**KIRKLEES METROPOLITAN COUNCIL
INVESTMENT & REGENERATION SERVICE**

**DELEGATED DECISION FOR APPLICATION FOR CERTIFICATE OF
LAWFUL DEVELOPMENT**

Reference no.: 2026/CL/92091/W

Site: 14, Lincroft Avenue, Dalton, Huddersfield, HD5
8DS

Client		Mr Smith	
Job		14 Lincroft Avenue Huddersfield	
Title		Existing Side Elevations	
Drawn By	RK	Date	July 2026
Eng. Check		Scale	1: 50
Tech. Check			
Drawing No.		Rev.	
2026 / 530 / 03

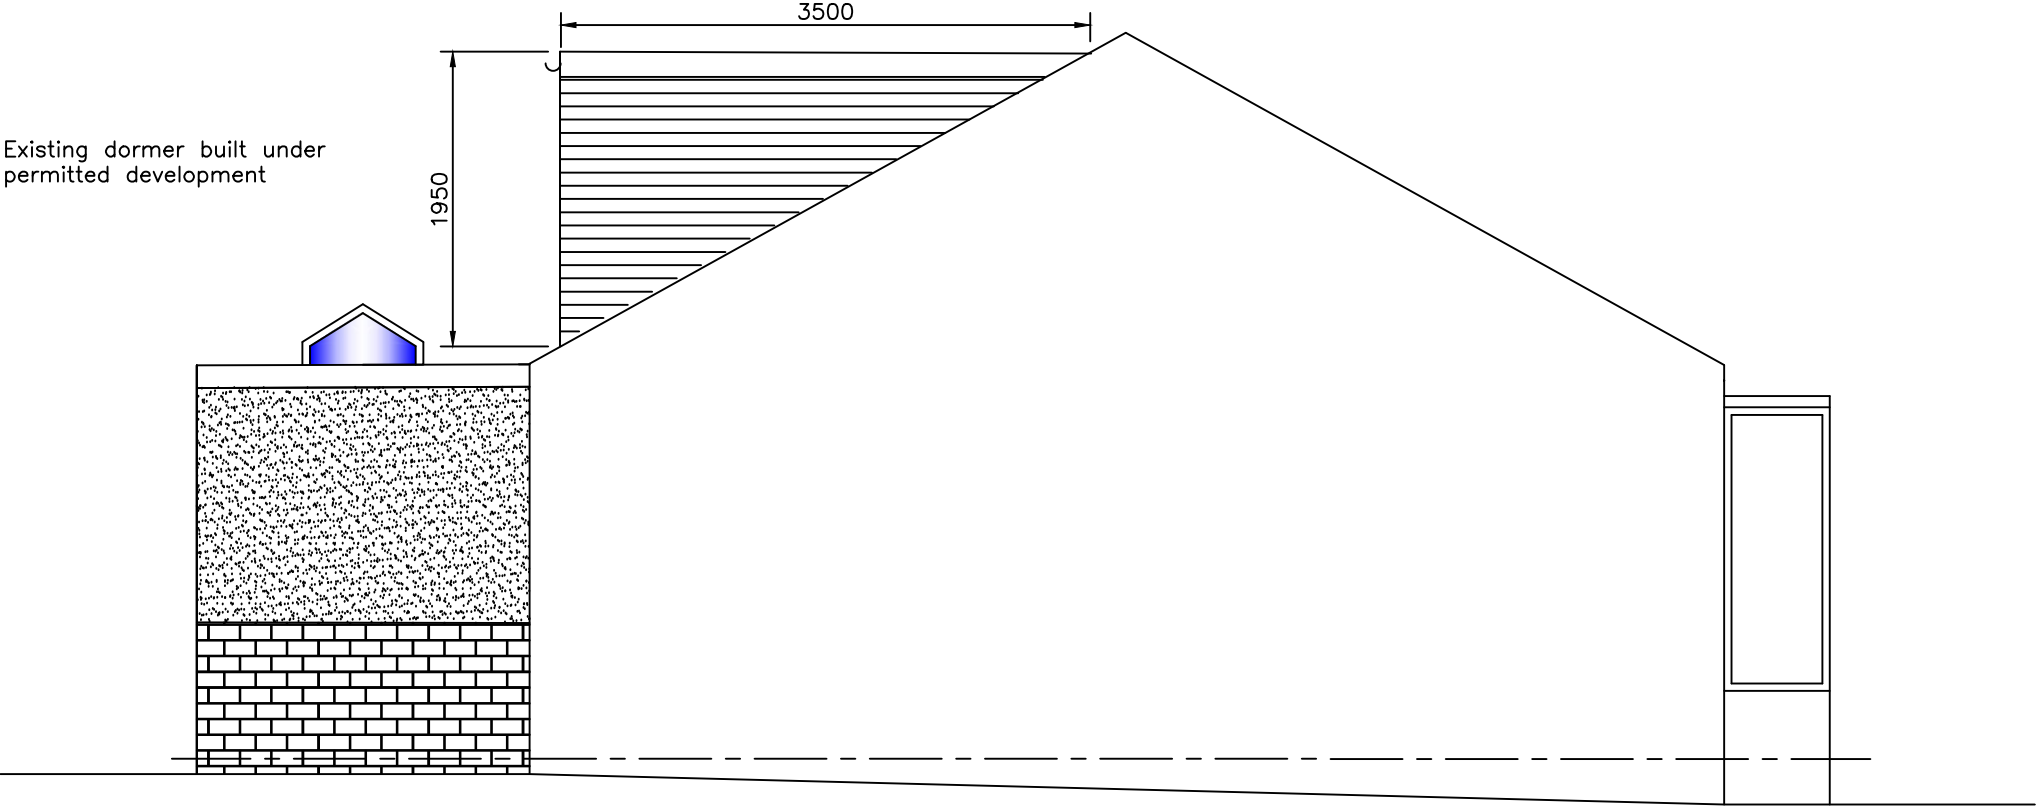
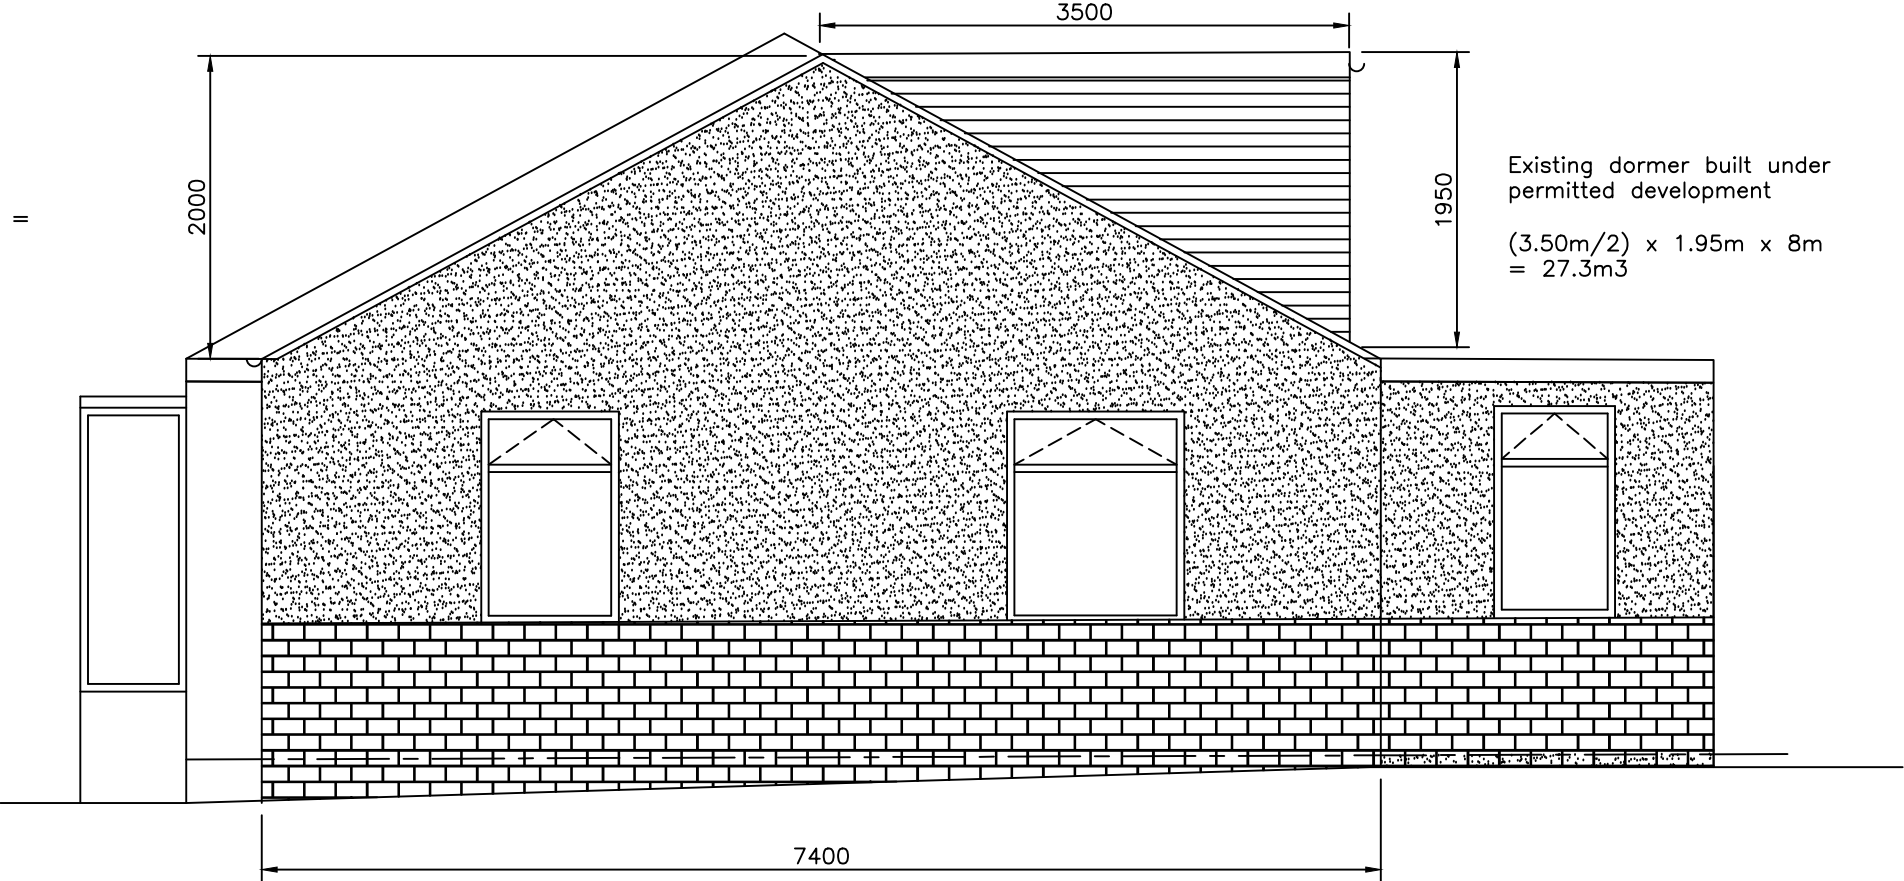
The submitted plans are annotated with the cubic volume of the side extension roof form. The plans state that the dimensions of the roof form are 7.4 metres x 2 metres x 3 metres. This would give a total roof volume for the side extension roof form as 22.2 cubic metres.

Comment: *The details contained within the submission include annotations on plan of the roof form of the side extension which is also additional roof space to be calculated as additional roof space. The dimensions of the side extension roof are 3m x 7.5m x 2m /2 which equate to 22.5m³. Therefore, when calculated with the dormer which has an increase of 27.3m³, this equates to 49.5m³ which is under the 50m³ threshold.*

Client		Mr Smith	
Job		14 Lincroft Avenue Huddersfield	
Title		Existing Front & Rear Elevation	
Drawn By	RK	Date	July 2026
Eng. Check		Scale	1: 50
Tech. Check			
Drawing No.		Rev.	
2026 /530 / 02

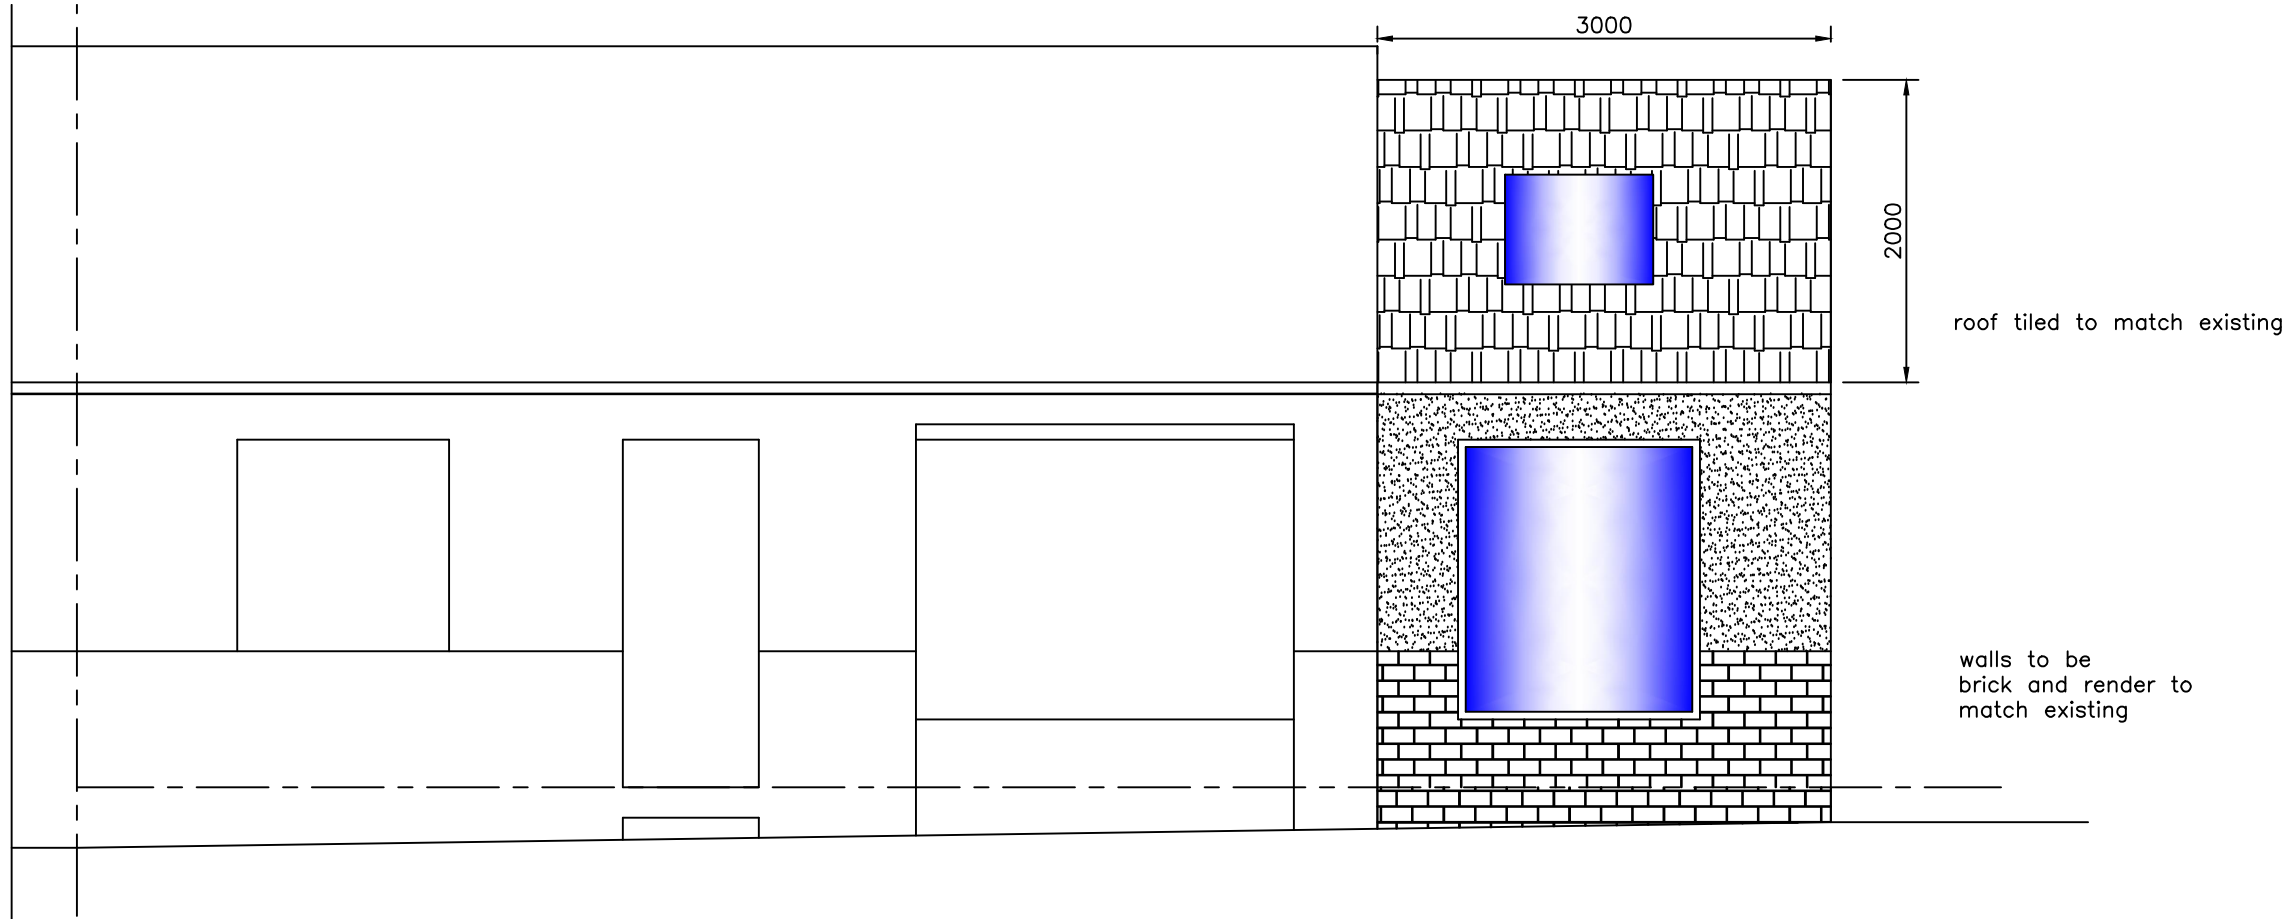
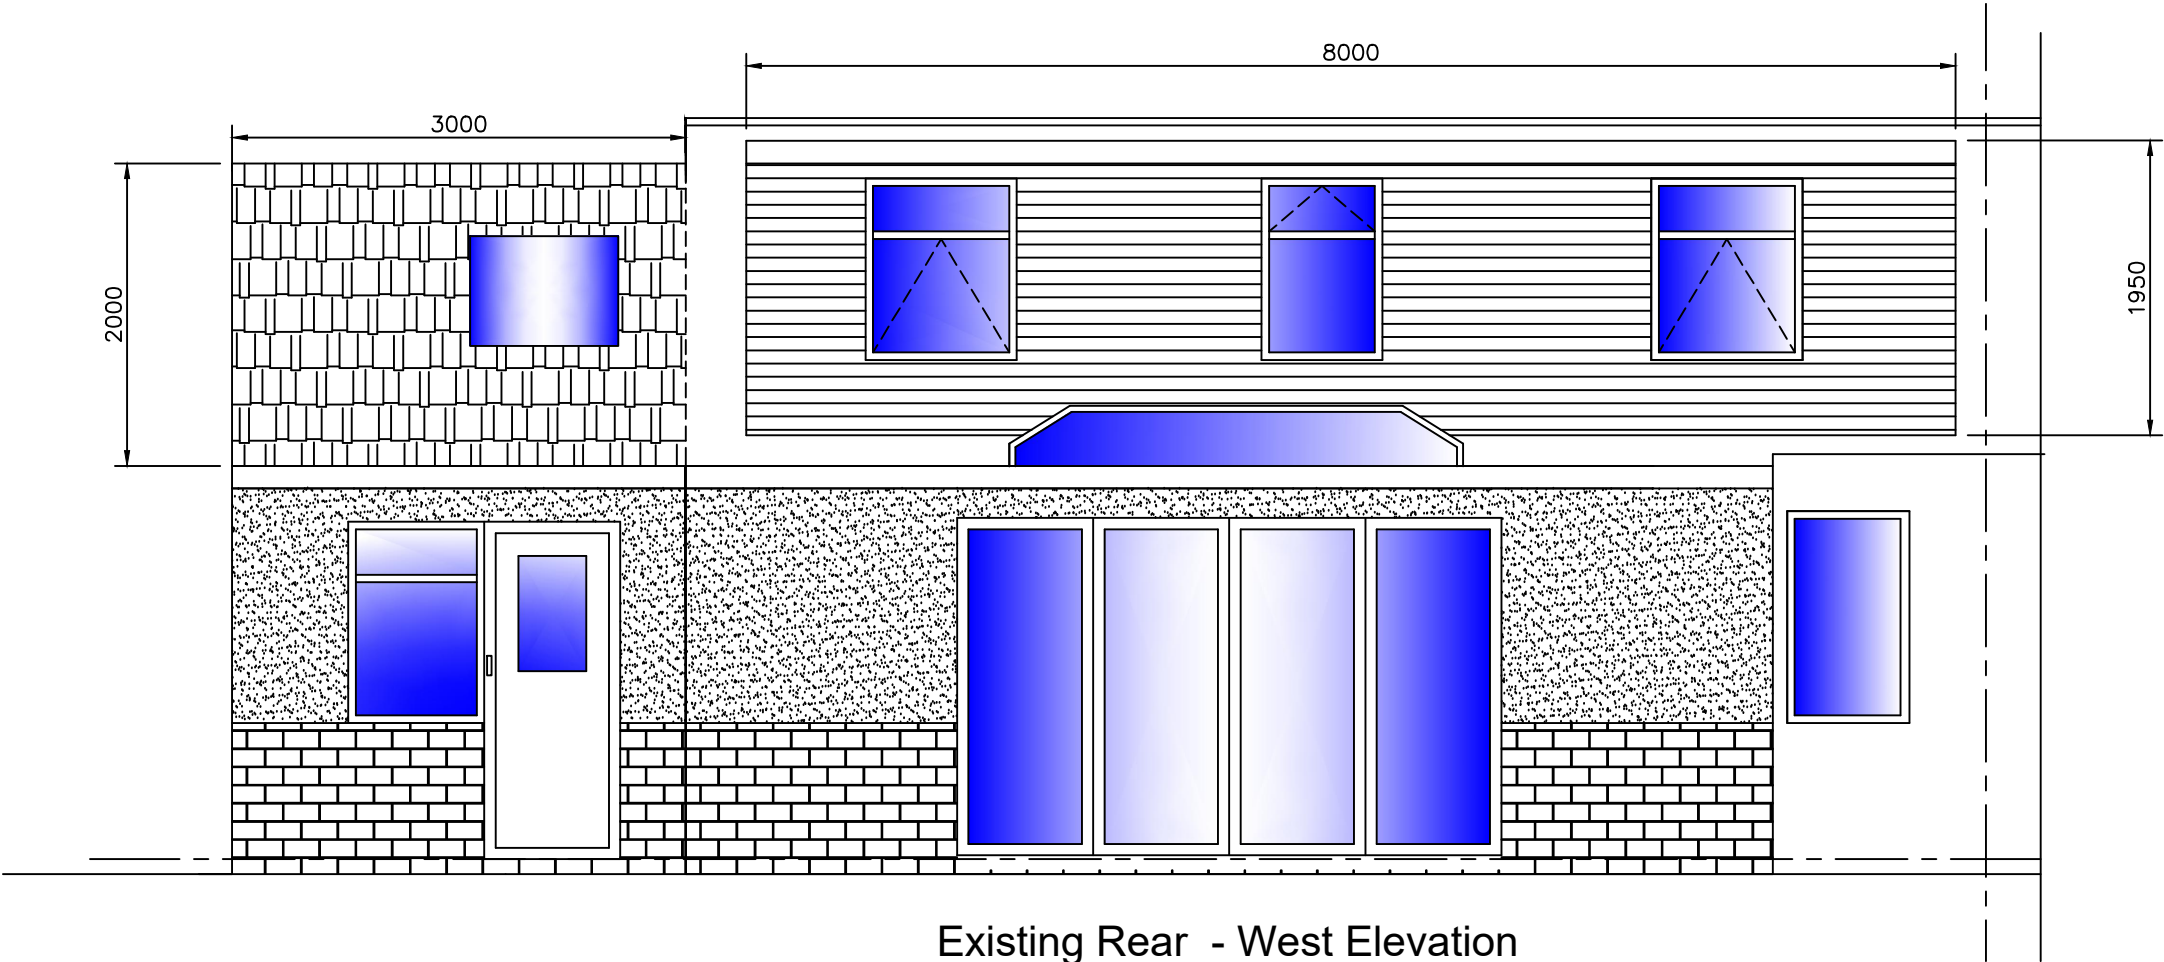
The dormer has been constructed and on rear elevation of the property set back from the existing eaves by 0.2 metres. It has a width of 8 metres, projection of 3.5 metre with a height of 1.95 metres. The total cubic volume increase from the dormer would be 27.3 cubic metres. A previous application for the dormer was refused due to not meeting the criteria set out within the regulations in terms of volume increase to the property. On the basis of a survey being undertaken to ascertain the exact measurements of the dormer extension, this application has been submitted.
